**LANDSCAPE PLAN**

**CRACKERJACK**  
7315 MCCLAIN POINT  
CBP LOT 21-2, EL PASO COUNTY, CO

NOT FOR CONSTRUCTION	JOB NUMBER	696-17
	REVISIONS	
	ORIGINAL DATE	6-28-17
	DRAWN BY:	JM
	DESCRIPTION:	LANDSCAPE PLAN
	SHEET NO.	LP-01

JOB NUMBER	696-17
REVISIONS	
8-26-17	PER COUNTY COMMENTS
ORIGINAL DATE	6-28-17
DRAWN BY:	JM
DESCRIPTION:	LANDSCAPE PLAN
SHEET NO.	LP-01
	PPR-17-031

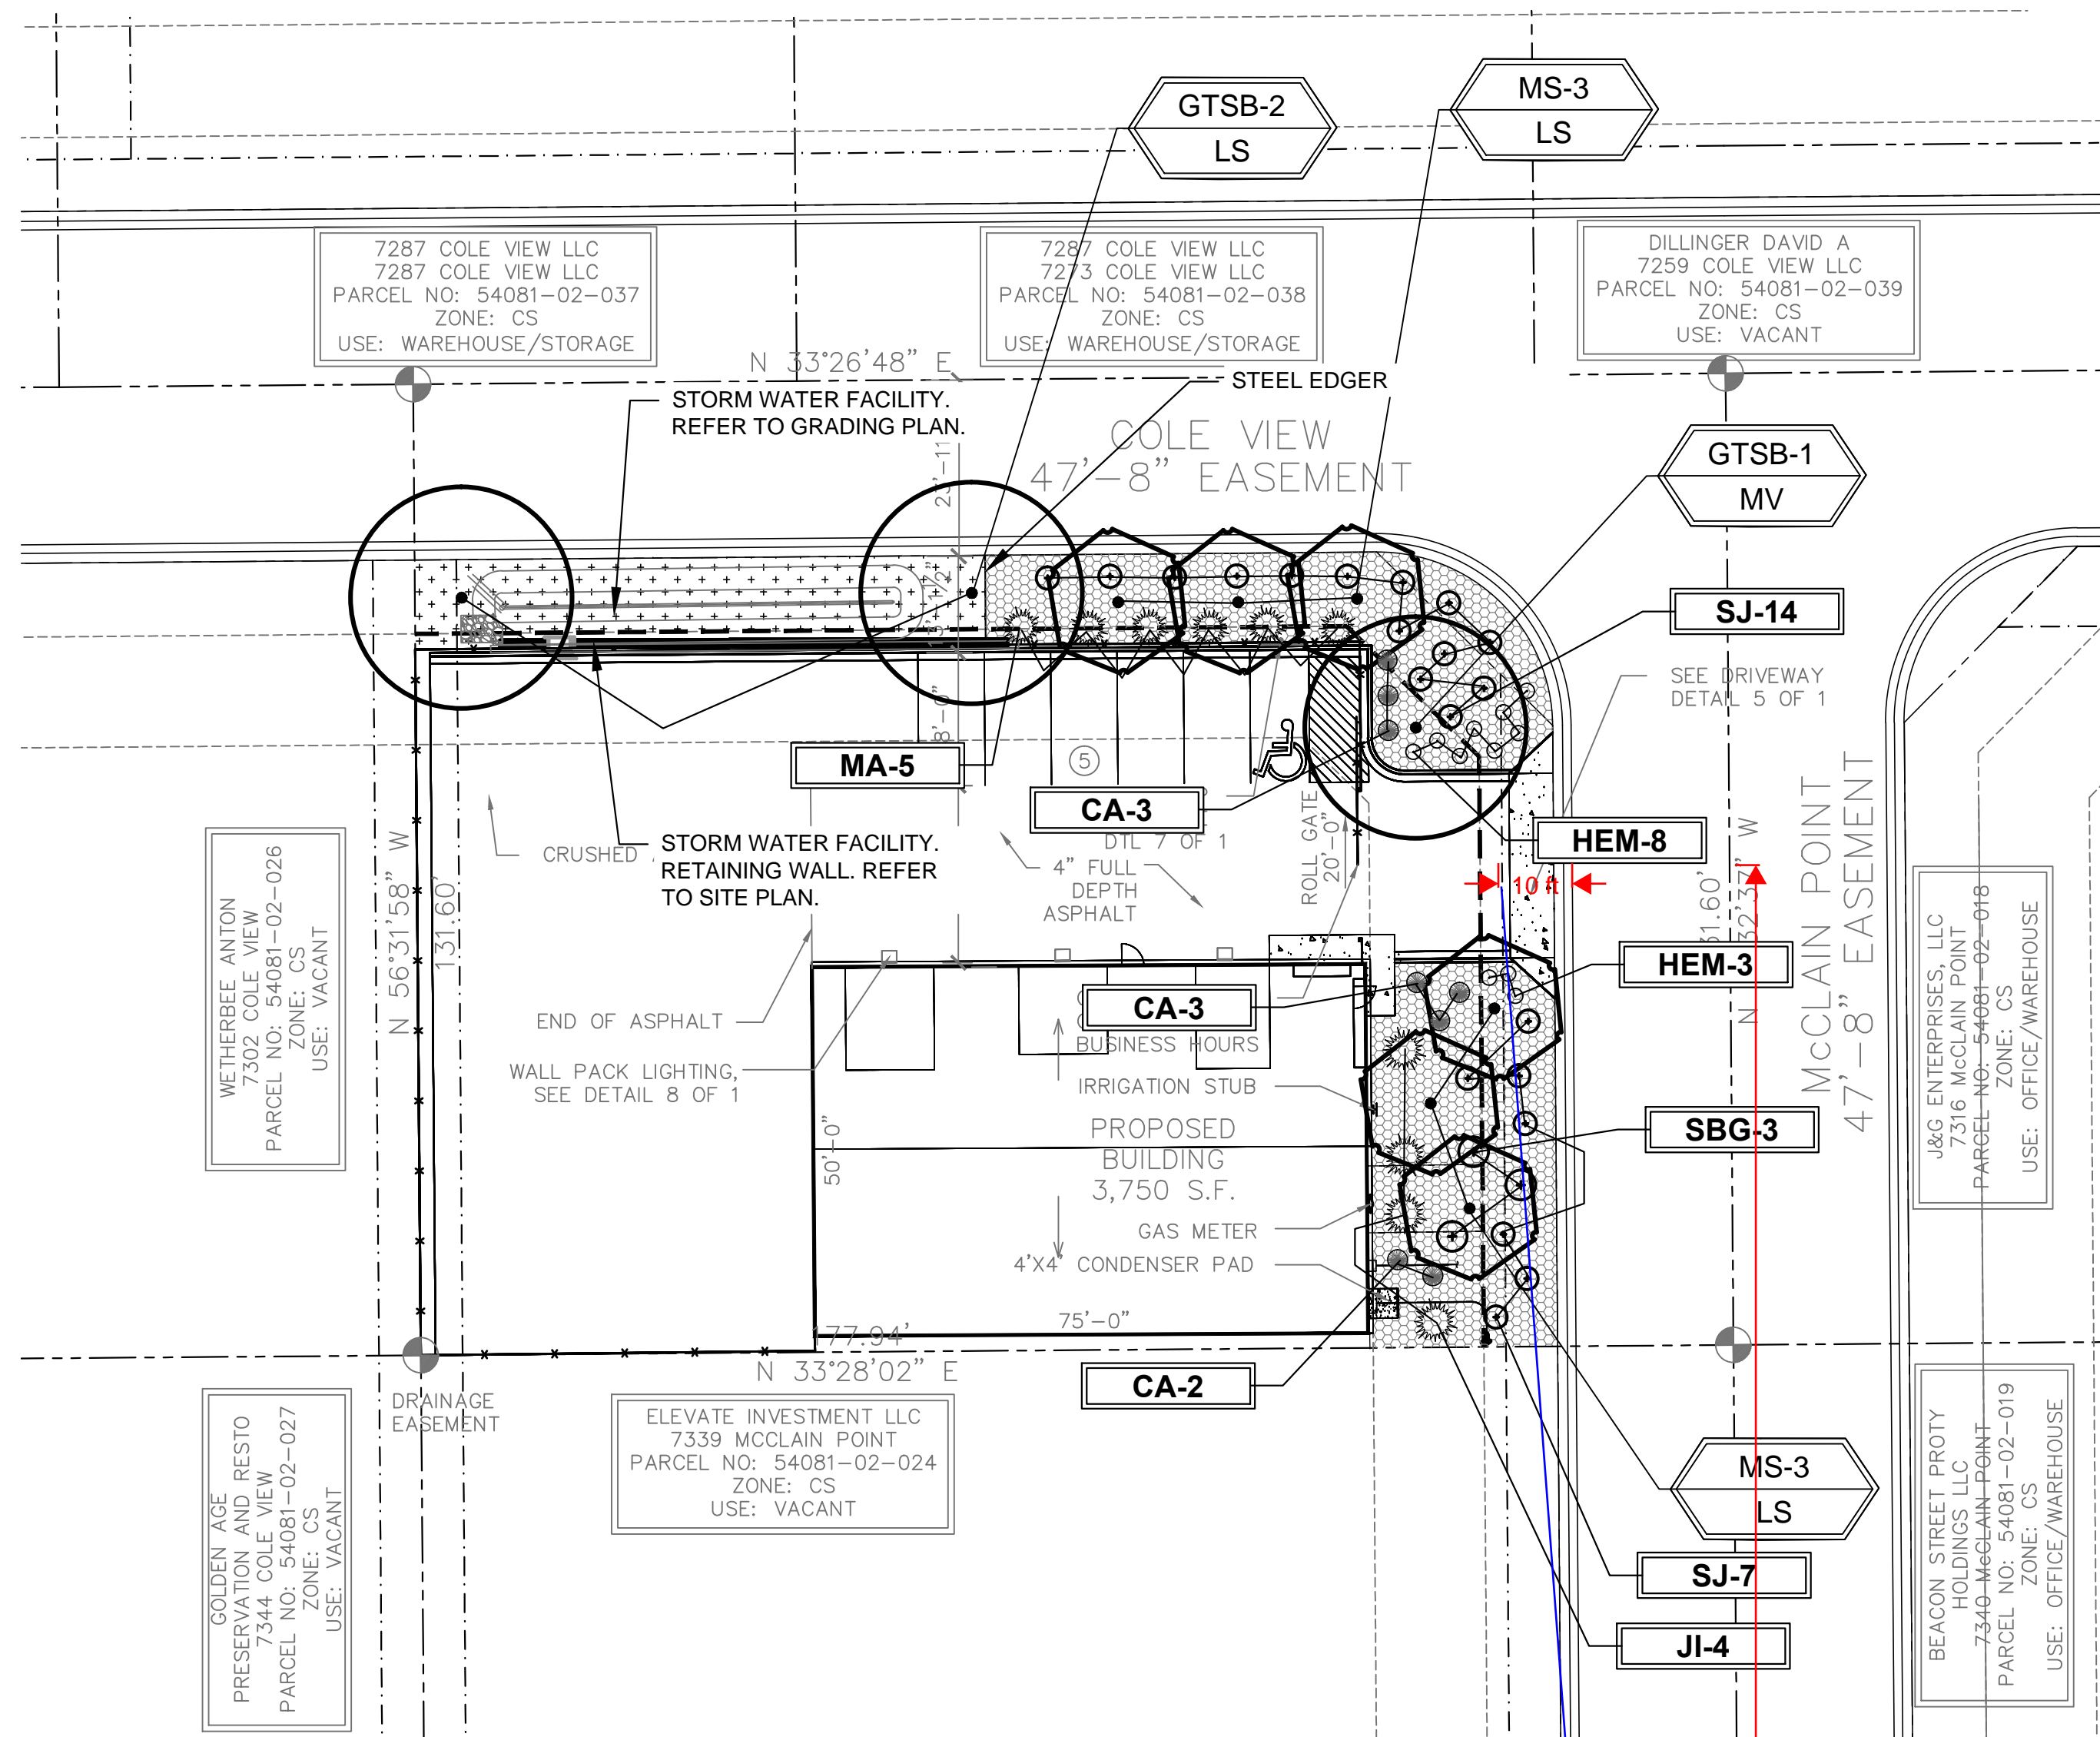
The LDC requires shrubs to be 3' or higher to screen headlights

Landscaping cannot be located in the 7' Public Utility Easement
